**EAST MIDLANDS GATEWAY PHASE 2 –
EAST MIDLANDS GATEWAY RAIL FREIGHT
INTERCHANGE MATERIAL CHANGE**

Written Representations

Leicestershire County Council

Planning Inspectorate Reference: BC0410001/TR0510002

drawing title  
BREEDING BIRD SURVEY RESULTS PLAN -  
DISTRIBUTION OF NOTABLE SPECIES

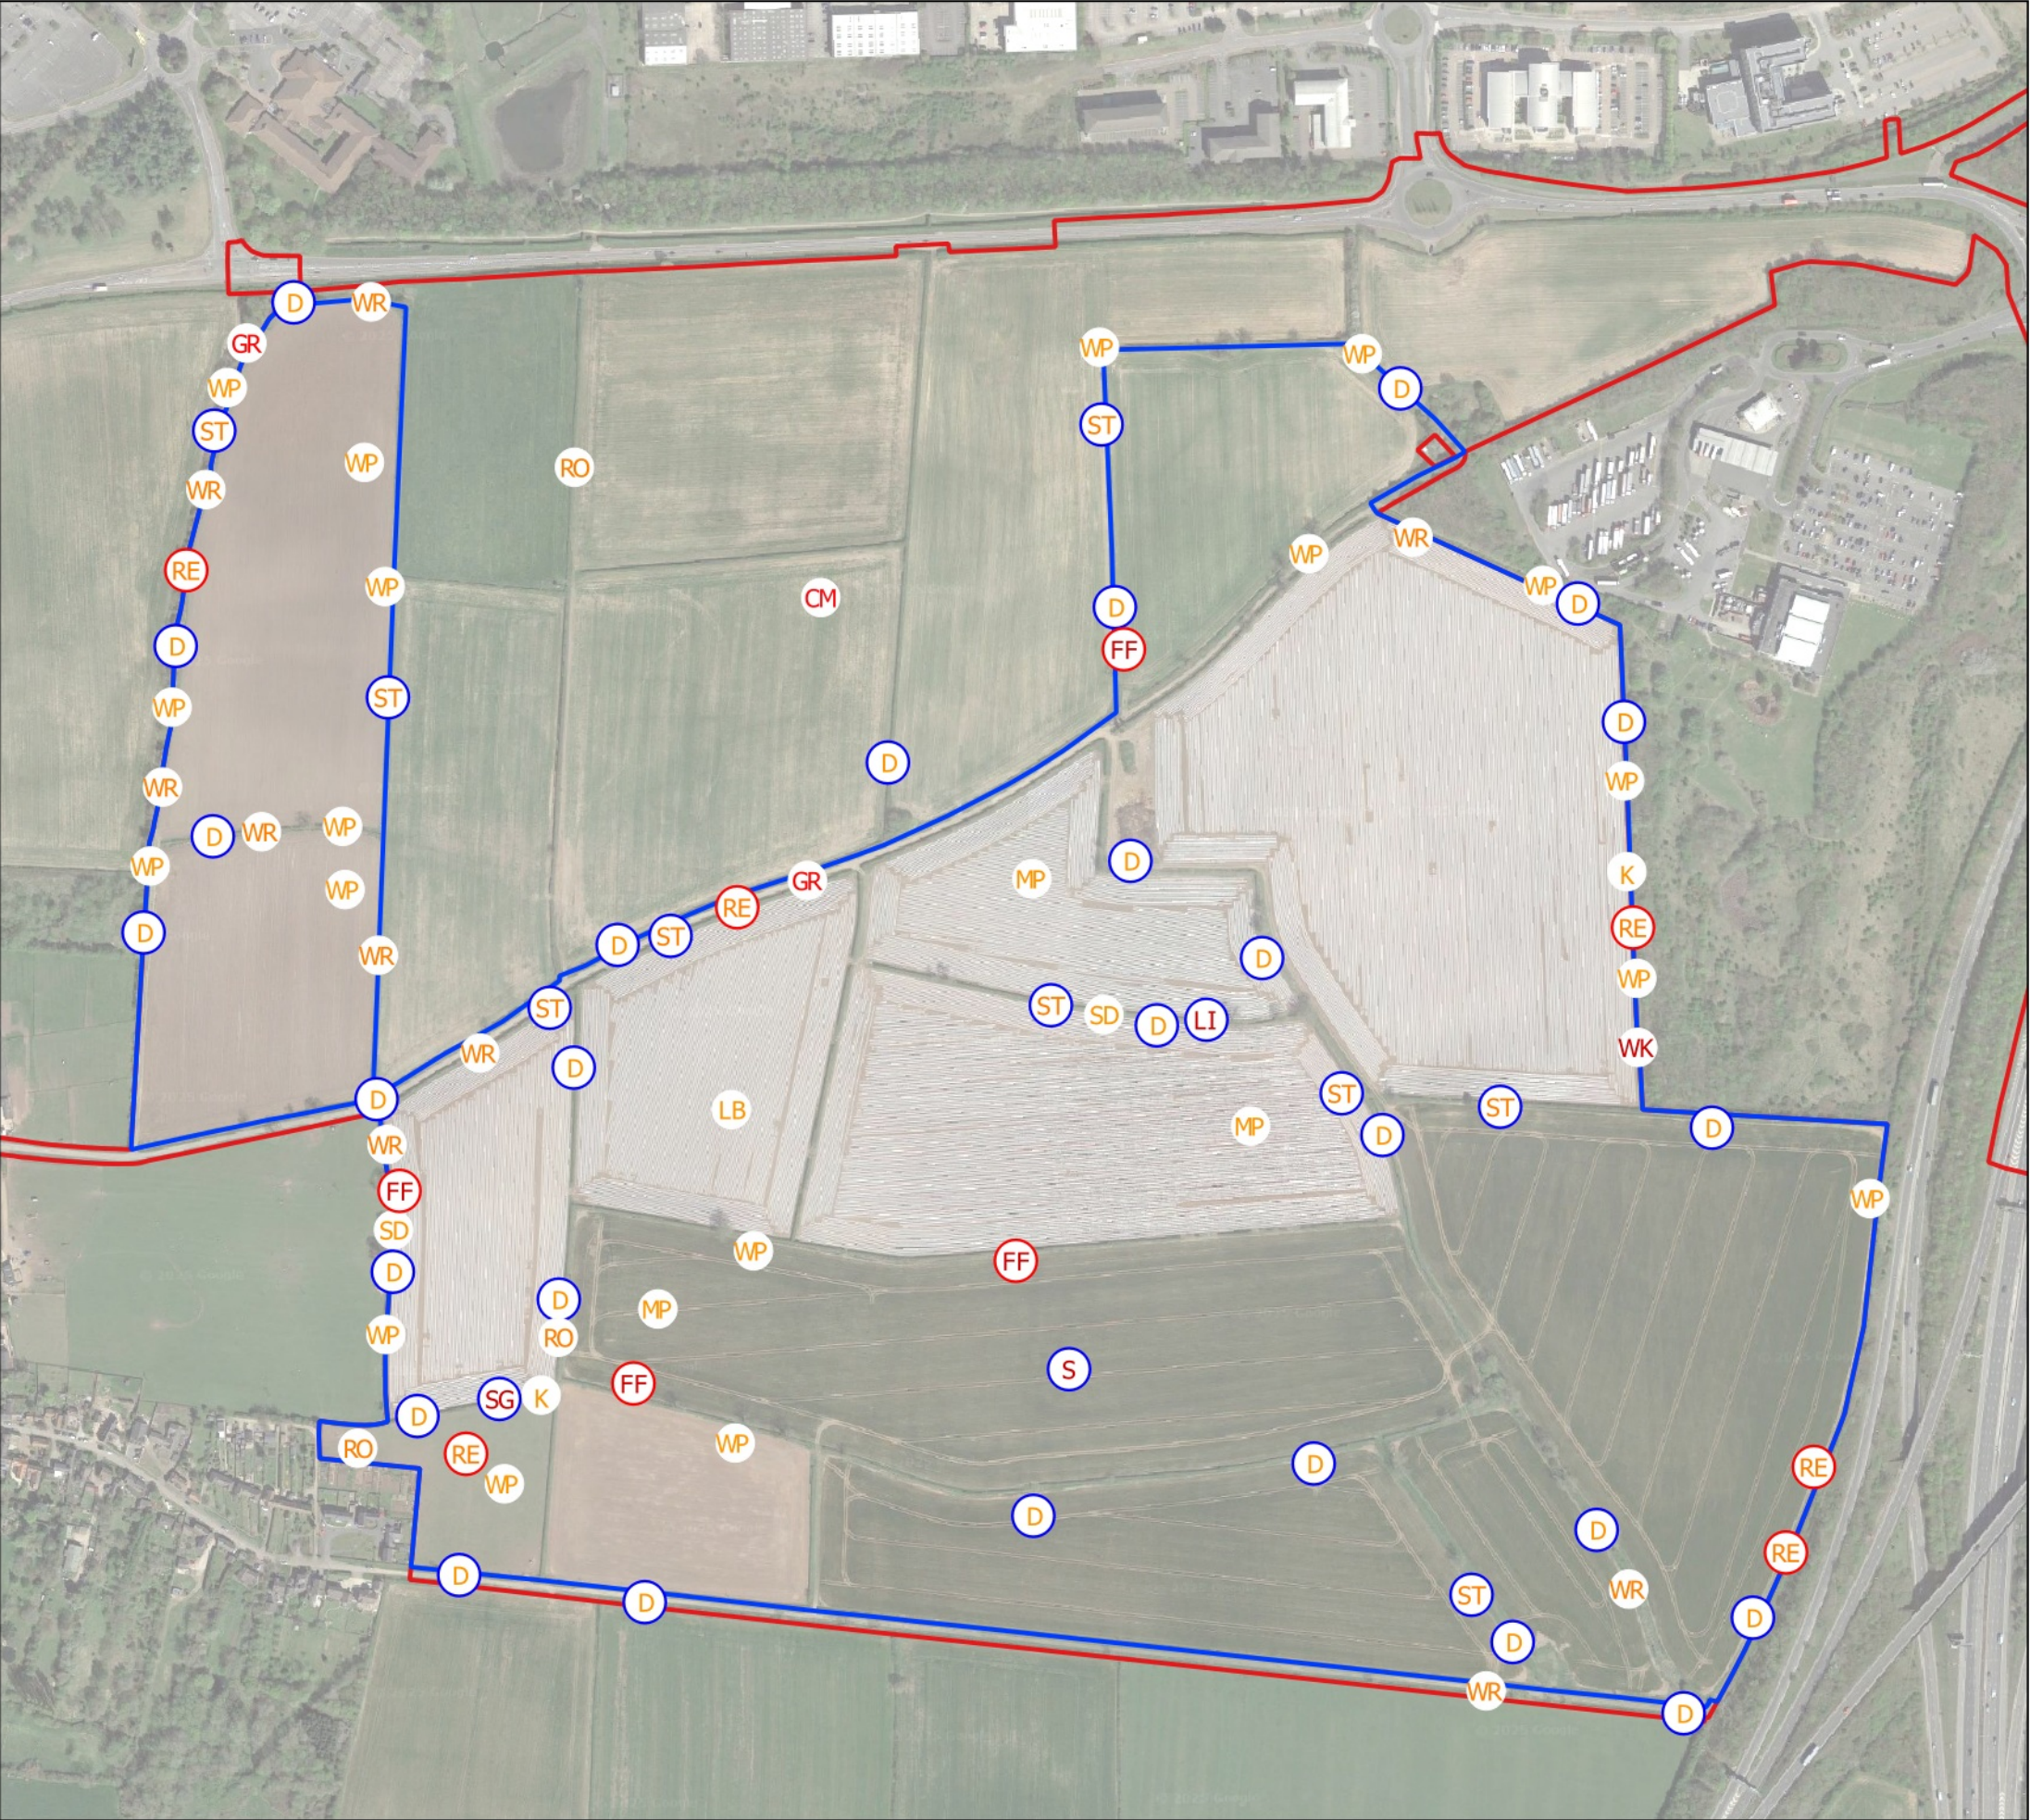
was provided in the form of a Bird Report [APP-111]. The report included information on previous bird surveys undertaken at the site, and the results of the breeding and wintering bird surveys between 2024-2025. Skylark were confirmed as breeding and a 'common resident', along with other Priority Species. The ES Chapter outlines the provision of grassland to provide alternative habitat and to support the carrying capacity of surrounding habitats, however suitable breeding habitat provision has not been provided.
